WEST SUSSEX COUNTY COUNCIL CONSULTATION

TO:	Arun District Council FAO: Anita Gardner
FROM:	WSCC - Highways Authority
DATE:	22 November 2019
LOCATION:	Land rear of 1 The Heathers Arundel Road Angmering BN16 4LE
SUBJECT:	A/146/19/PL Demolition of existing storage building & erection of a 3-bedroom chalet bungalow with associated parking & landscaping.
DATE OF SITE VISIT:	n/a
RECOMMENDATION:	Advice
S106 CONTRIBUTION TOTAL:	n/a

Proposed Bungalow
Plans and Elevations

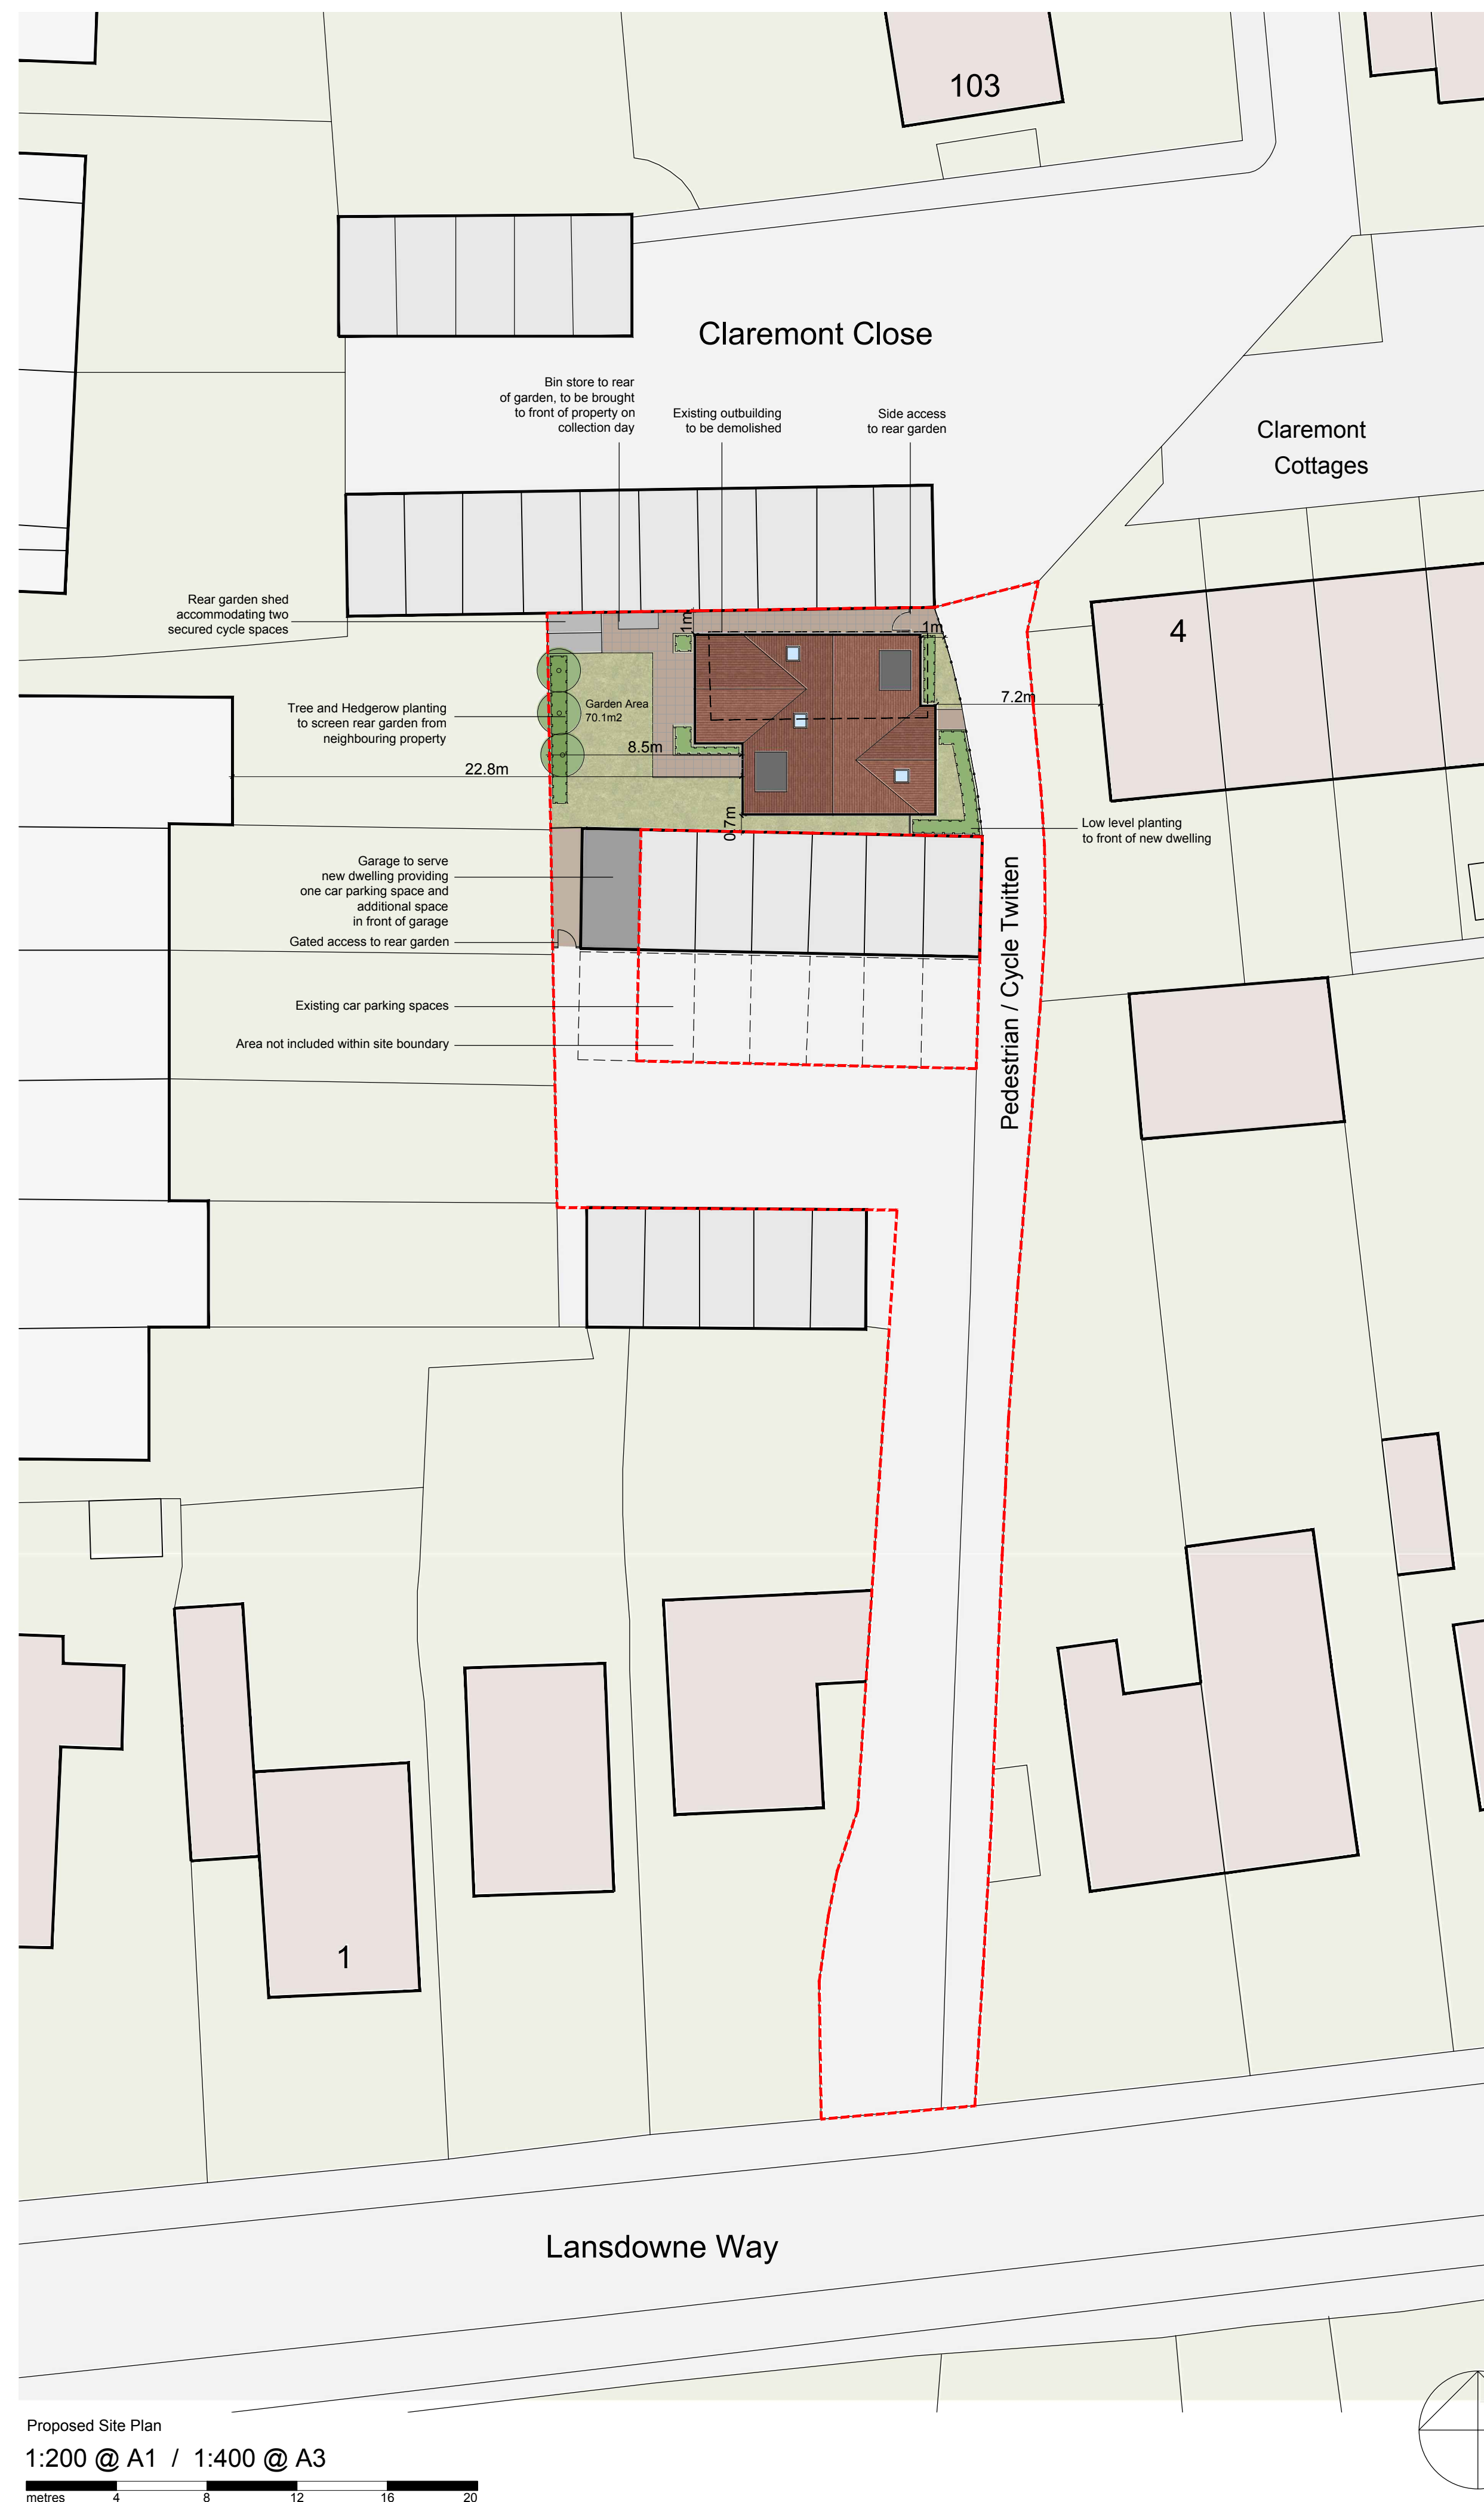
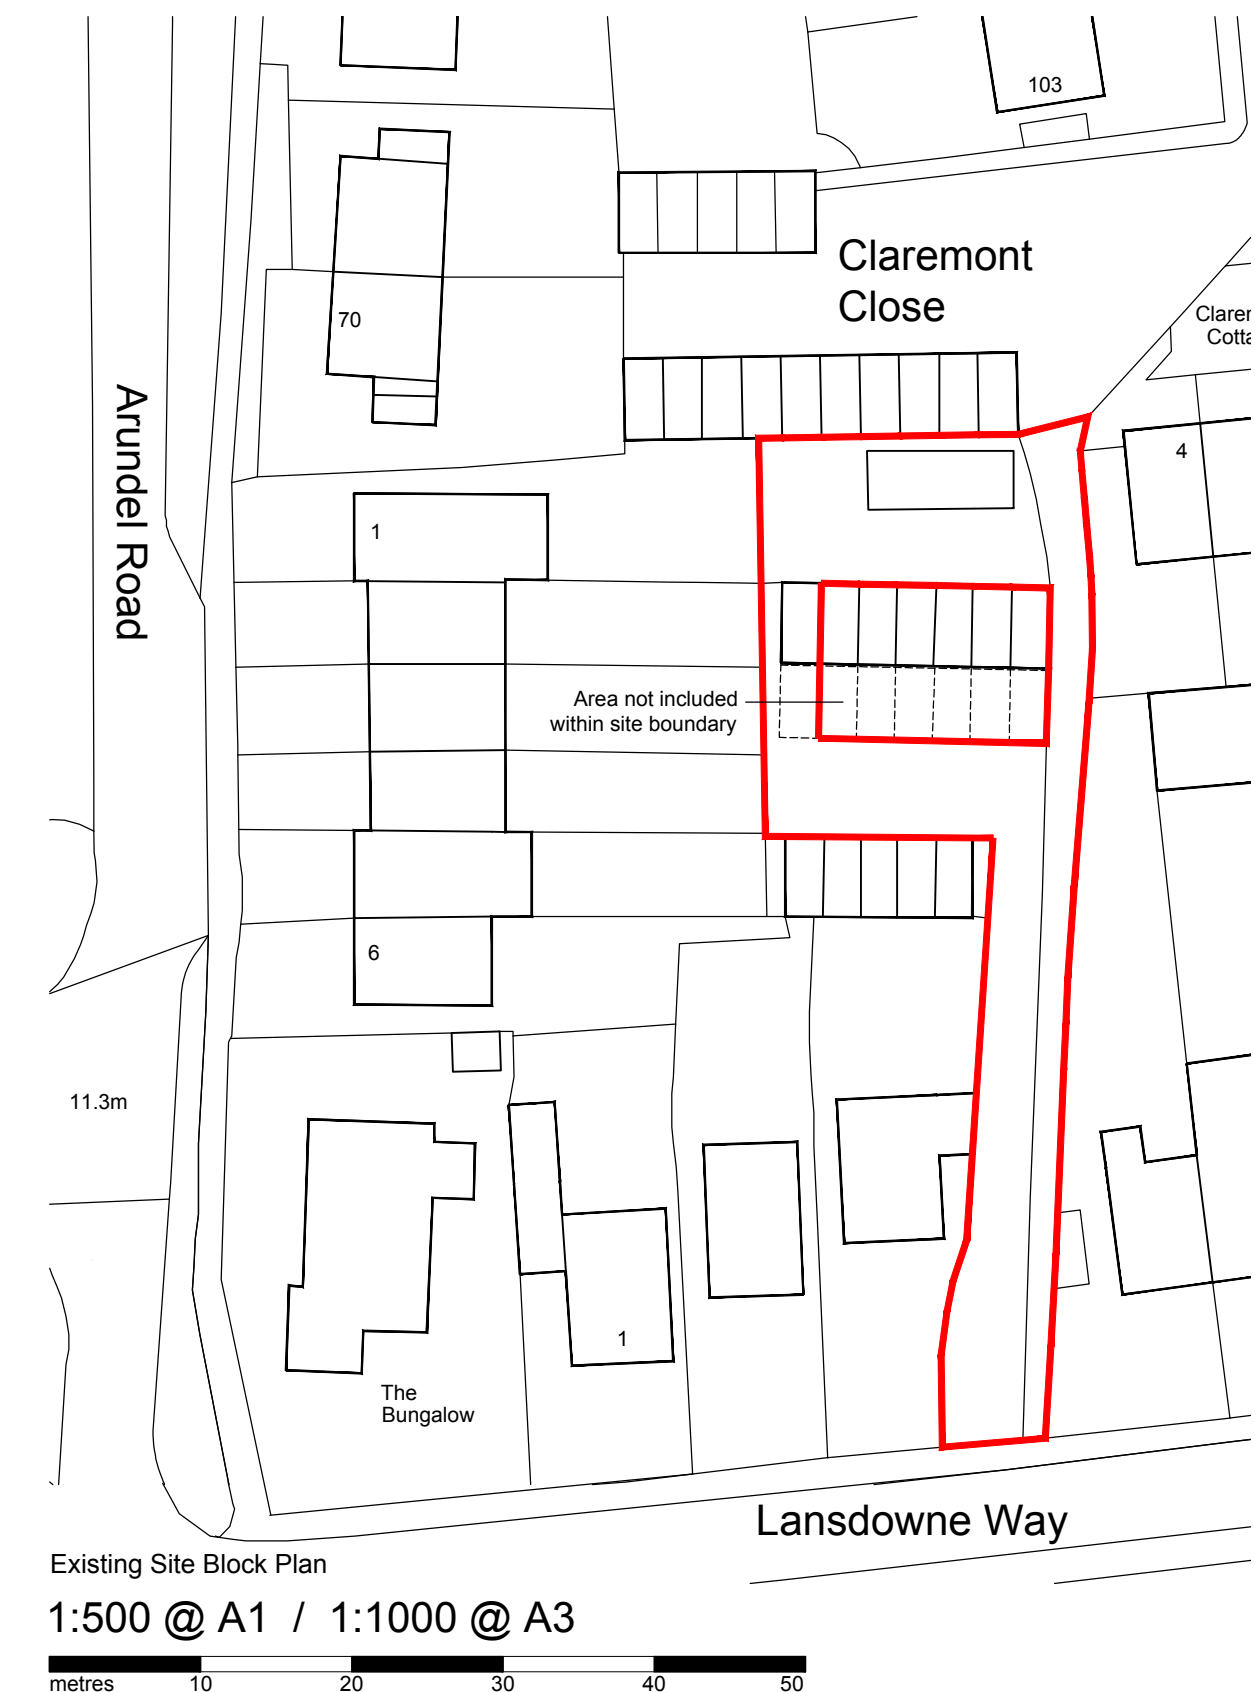
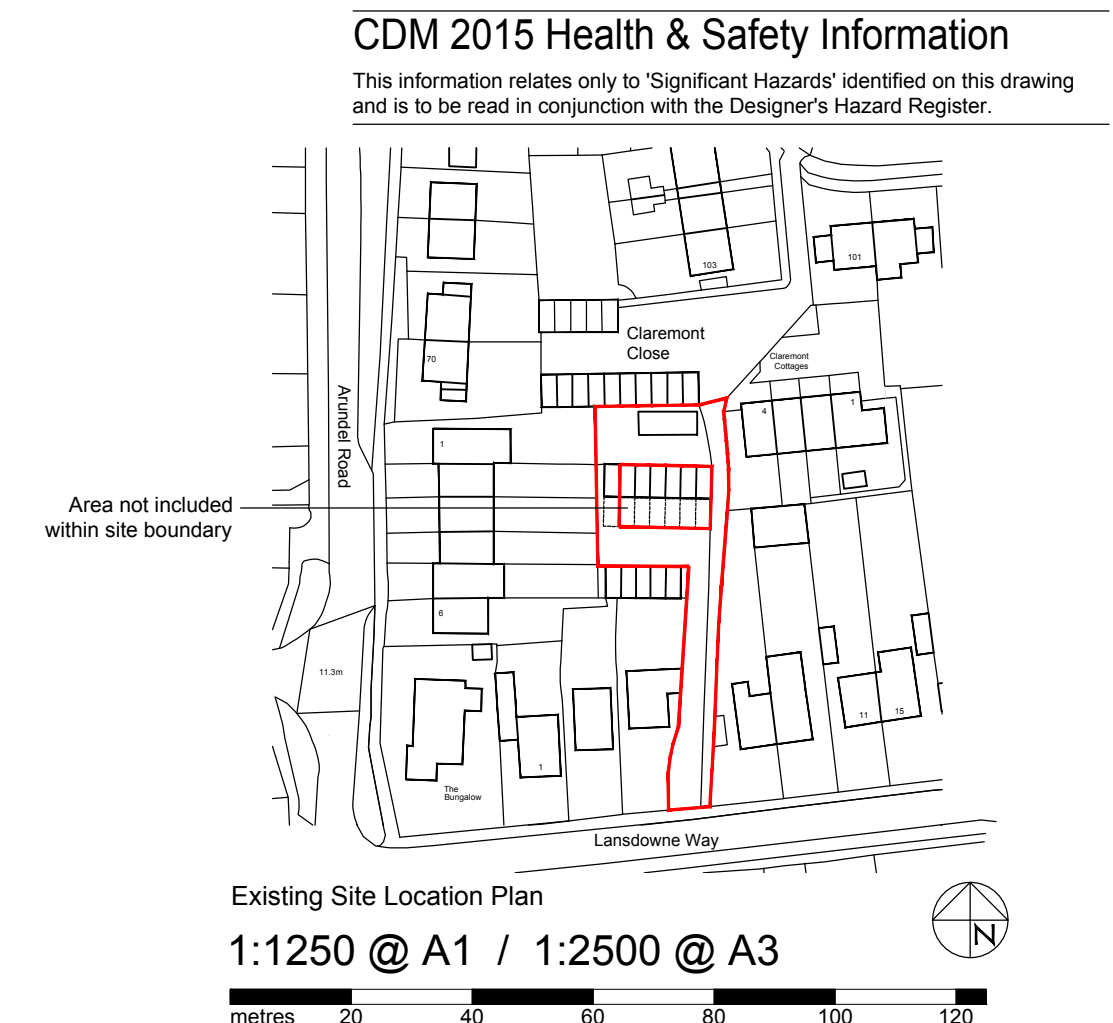
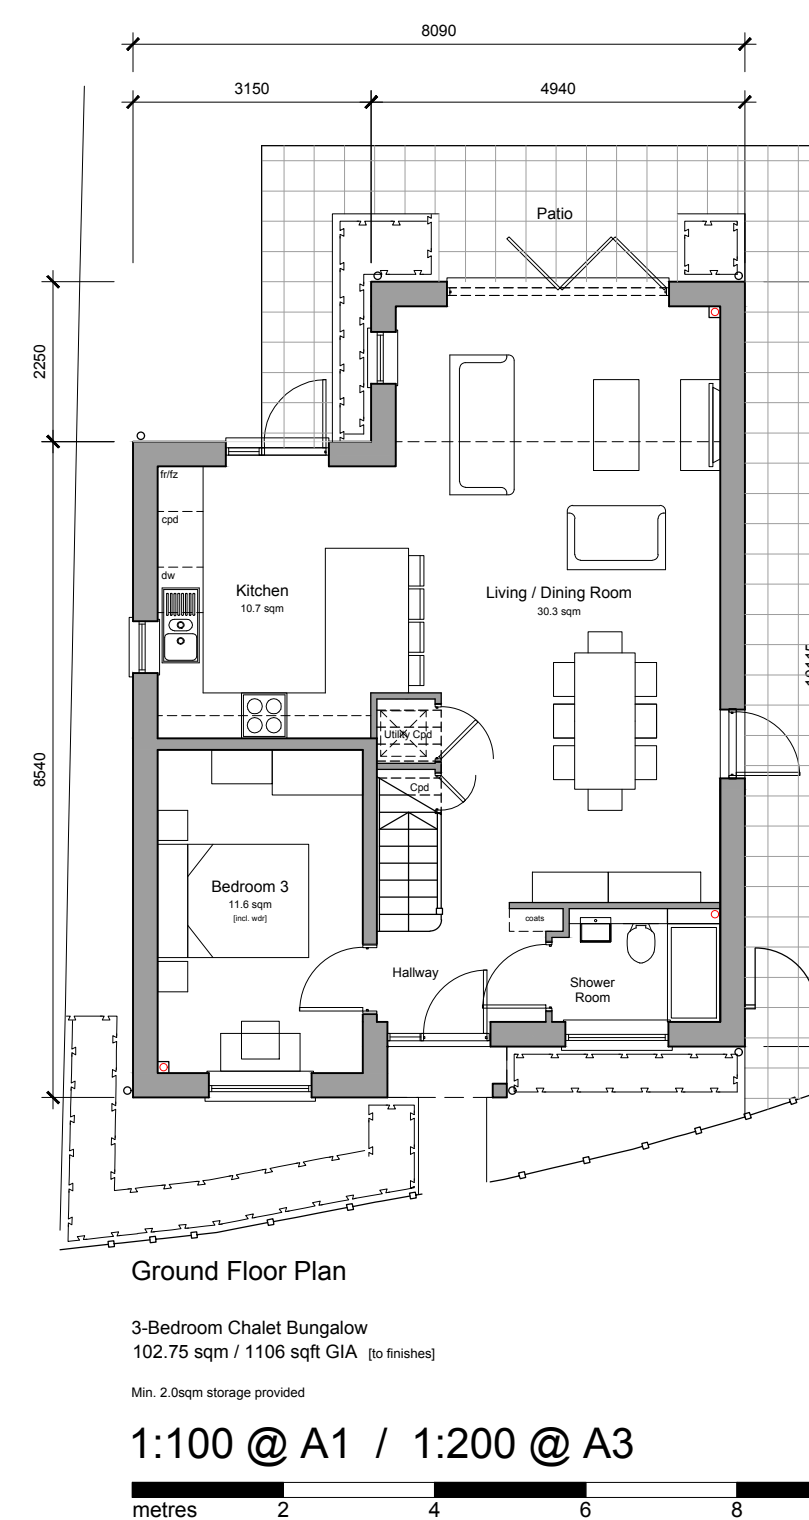
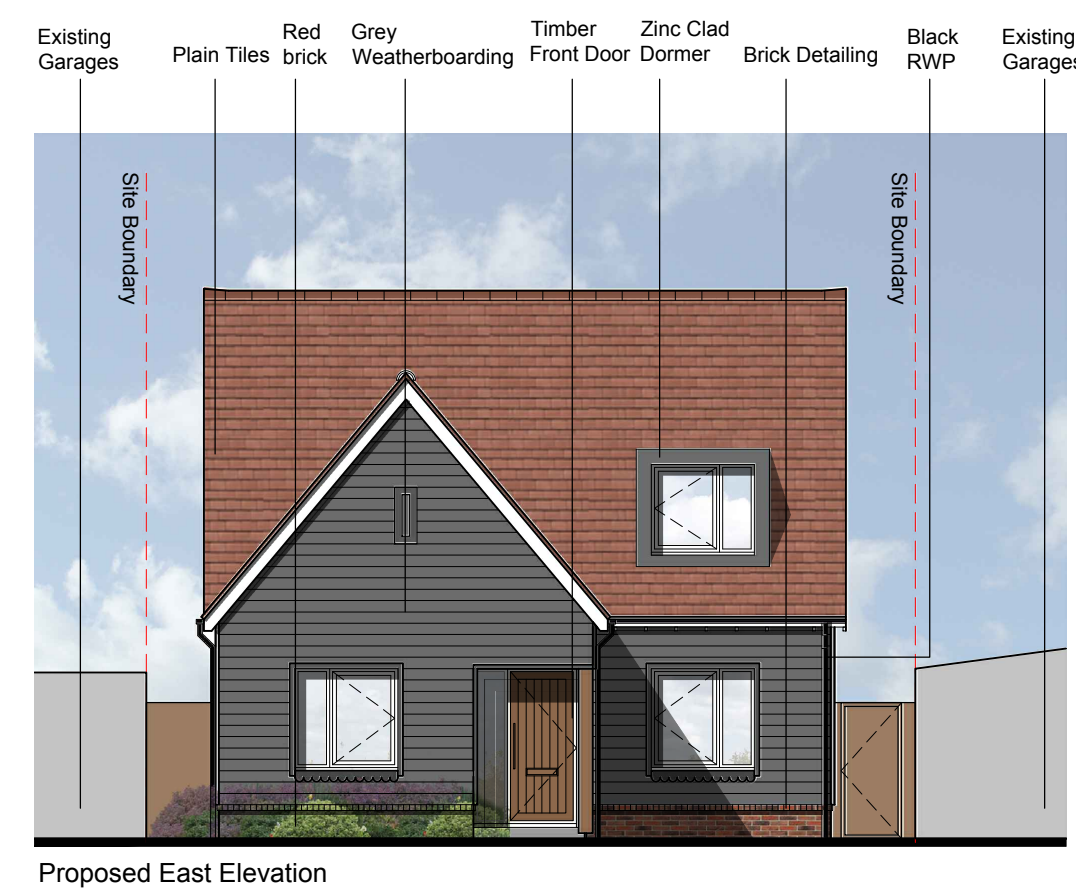
A second access is located on foot via Lansdowne Way to Goring Close a publicly maintained footway. It appears that the gate/access path from the footway to the dwelling may result in a conflict with a street lighting pole. The applicant is advised to contact the operator in regards to the possible relocation works associated.

After inspection of these plans, the LHA advise that the garage (2.6 x 5.3 metres) does not conform to WSCC and Manual for Streets (MfS) guidance for garage dimensions (3 x 6 metres). On this basis the LHA will not consider the garage towards the parking provision of the site.
